Rezoning Transportation Analysis

Petition Number: 2020-068

Date	Description
05-18-20	First Review
06-28-20	Second Review
09-22-20	Third Review (LJensen)

RZ-1

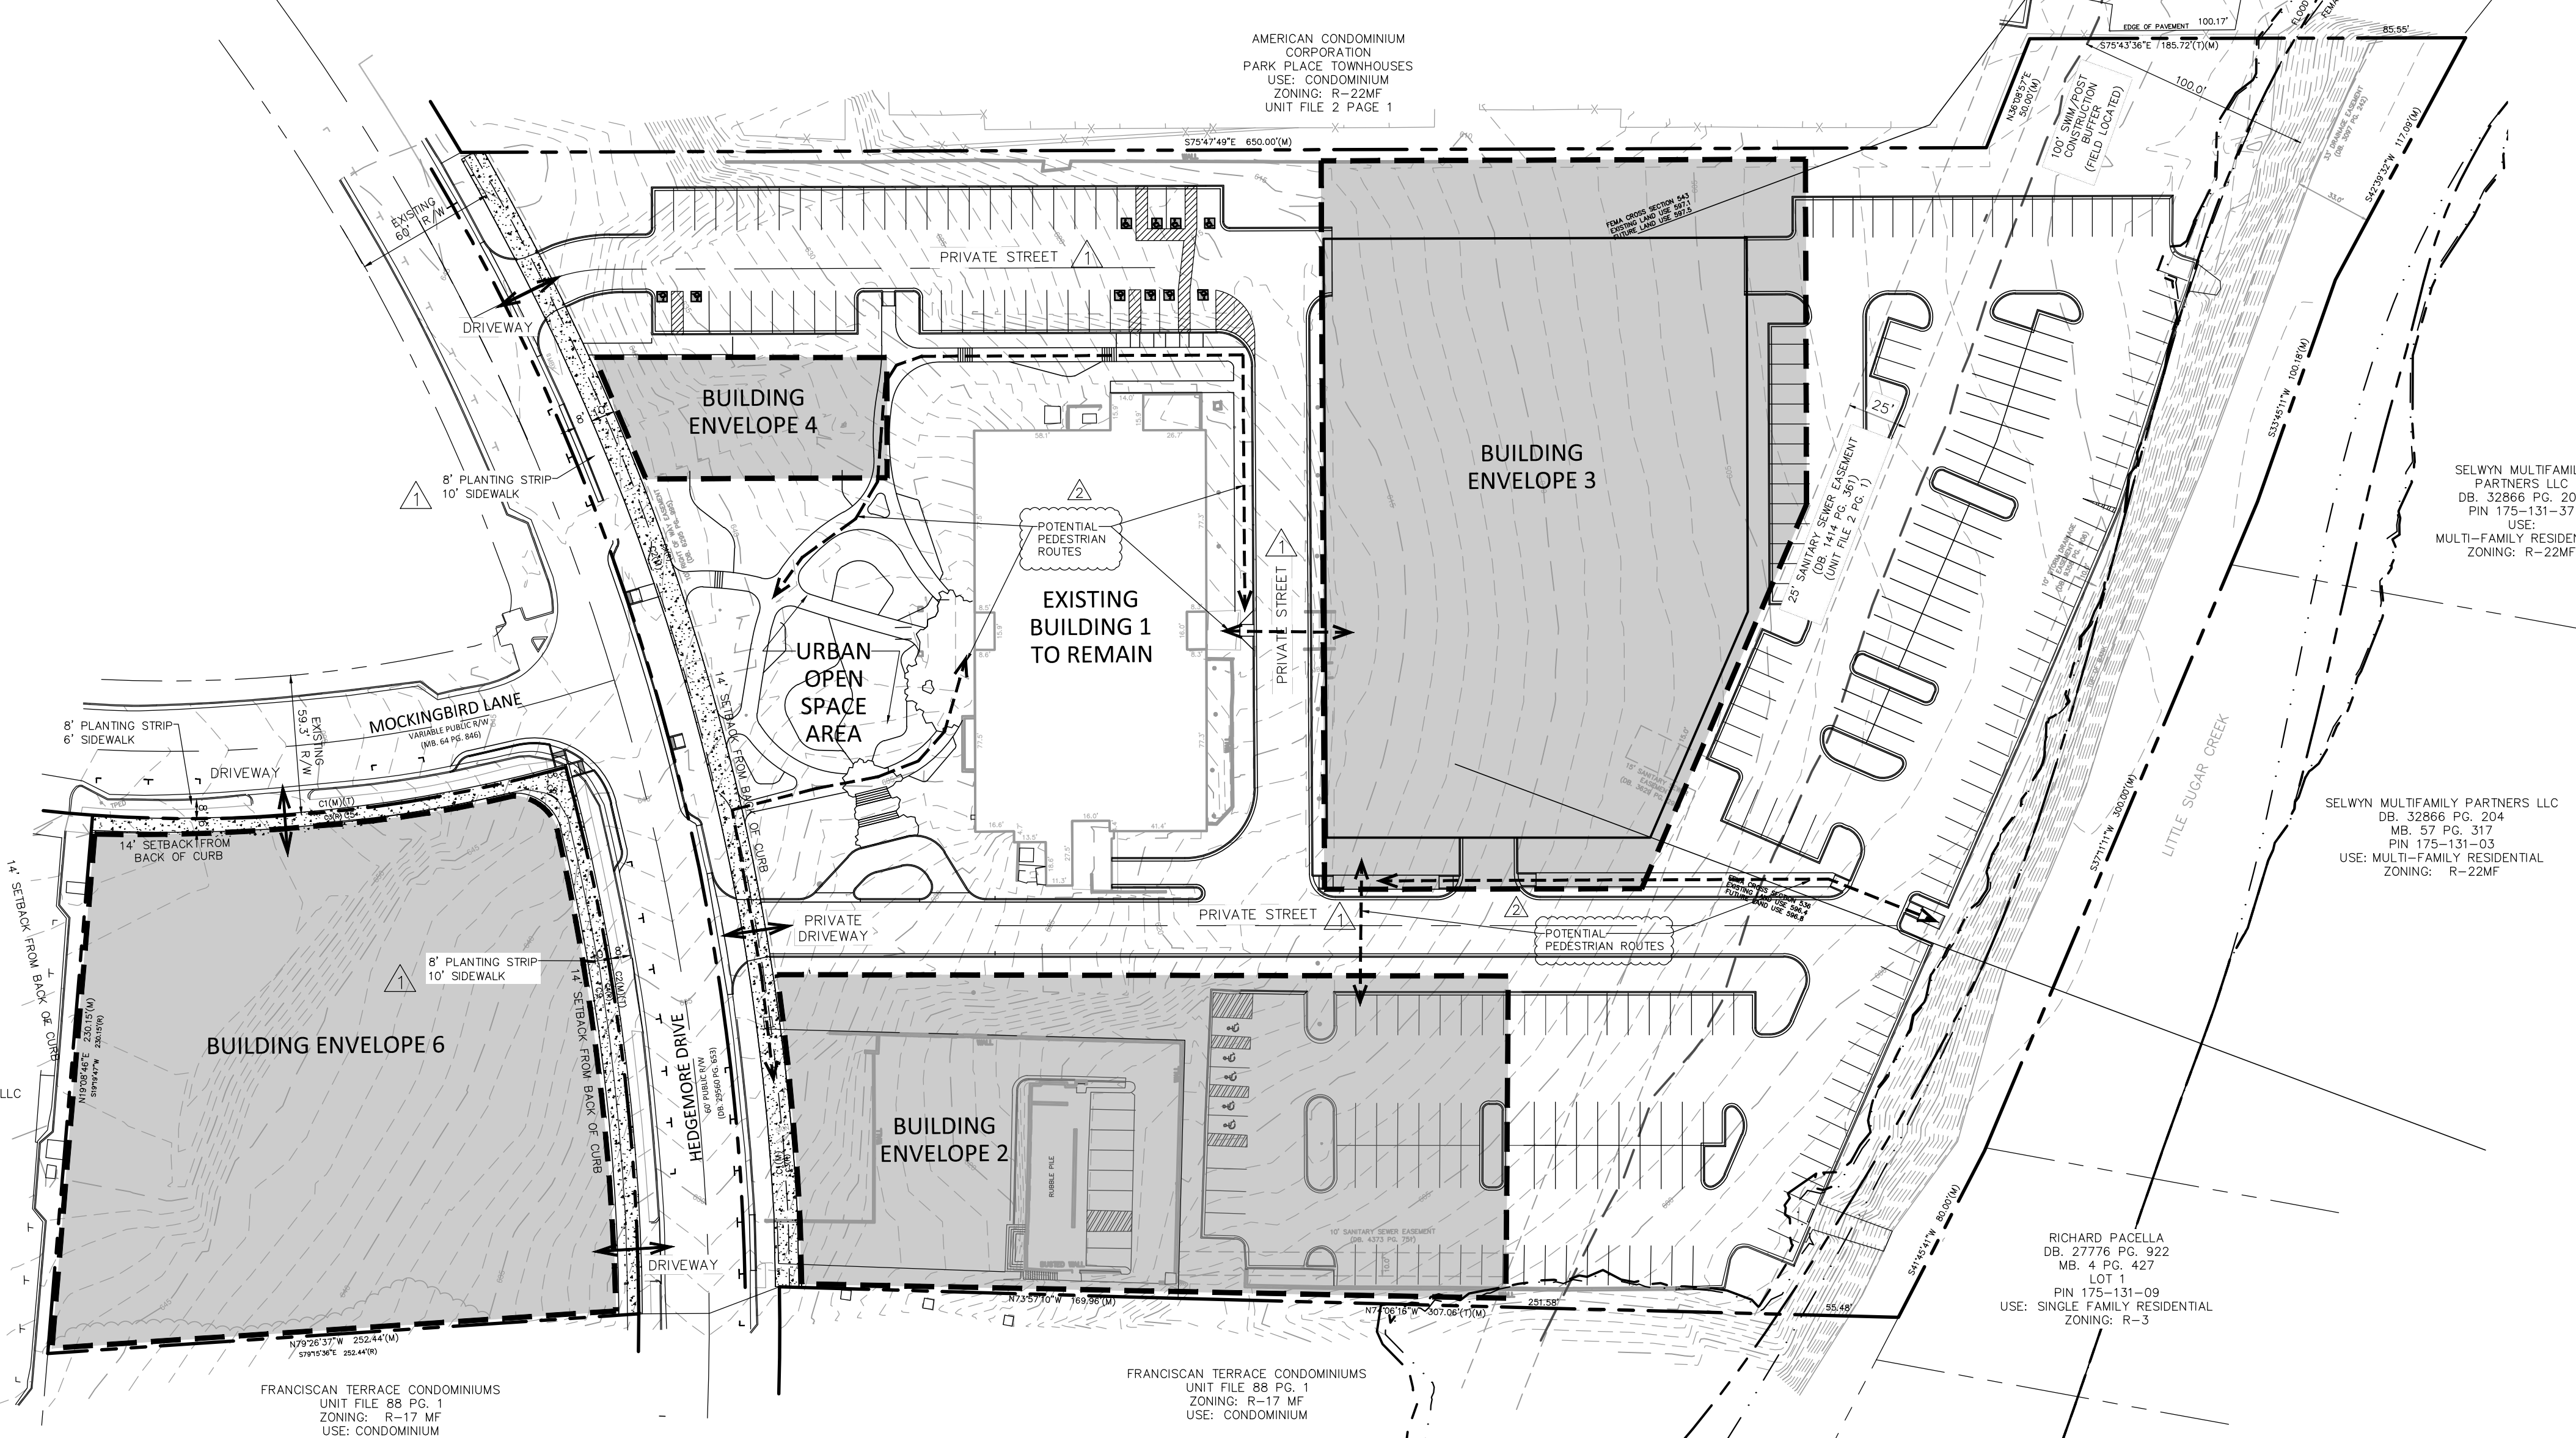
1. **Curblines** The proposed zoning district has a setback measured from back of the existing or proposed future curblines.
 - a. **Hedgemore Drive:** The future location of curb and gutter is in its existing location.
 - b. **Mockingbird Lane:** The future location of curb and gutter is in its existing location.

Label and dimension the curb and gutter from the centerline for each road.

- CDOT requests that the petitioner revises the site plan and conditional note(s) to commit to a 12' multi-use path connecting Hedgemore Drive to the Cross Charlotte Trail (XCLT) including a pedestrian bridge over Little Sugar Creek east of the site, to meet the City of Charlotte BIKE Policy. CDOT also requests a public access easement with parking and a trailhead to the XCLT as a Traffic Demand Management (TDM) measure.

- The petitioner should revise the site plan and conditional note(s) to commit to constructing an 8-foot planting strip, and an 8-foot sidewalk on Mockingbird Lane per the Park Woodlawn Area Plan. Label and dimension both items from the back of curb and gutter to the road centerline.

- Revise the site plan to add a note specifying dedication and fee simple conveyance of all rights of way to the City before the site's first building certificate of occupancy is issued. CDOT requests right of way set at 2' behind back of sidewalk where feasible.
- Revise the site plan to add a note specifying all transportation improvements will be approved and constructed before the site's first building certificate of occupancy is issued. The petitioner may phase transportation improvements if said improvements and phasing are explicitly described in site plan notes.
- ~~Resolved~~ Sample format for comment that is resolved
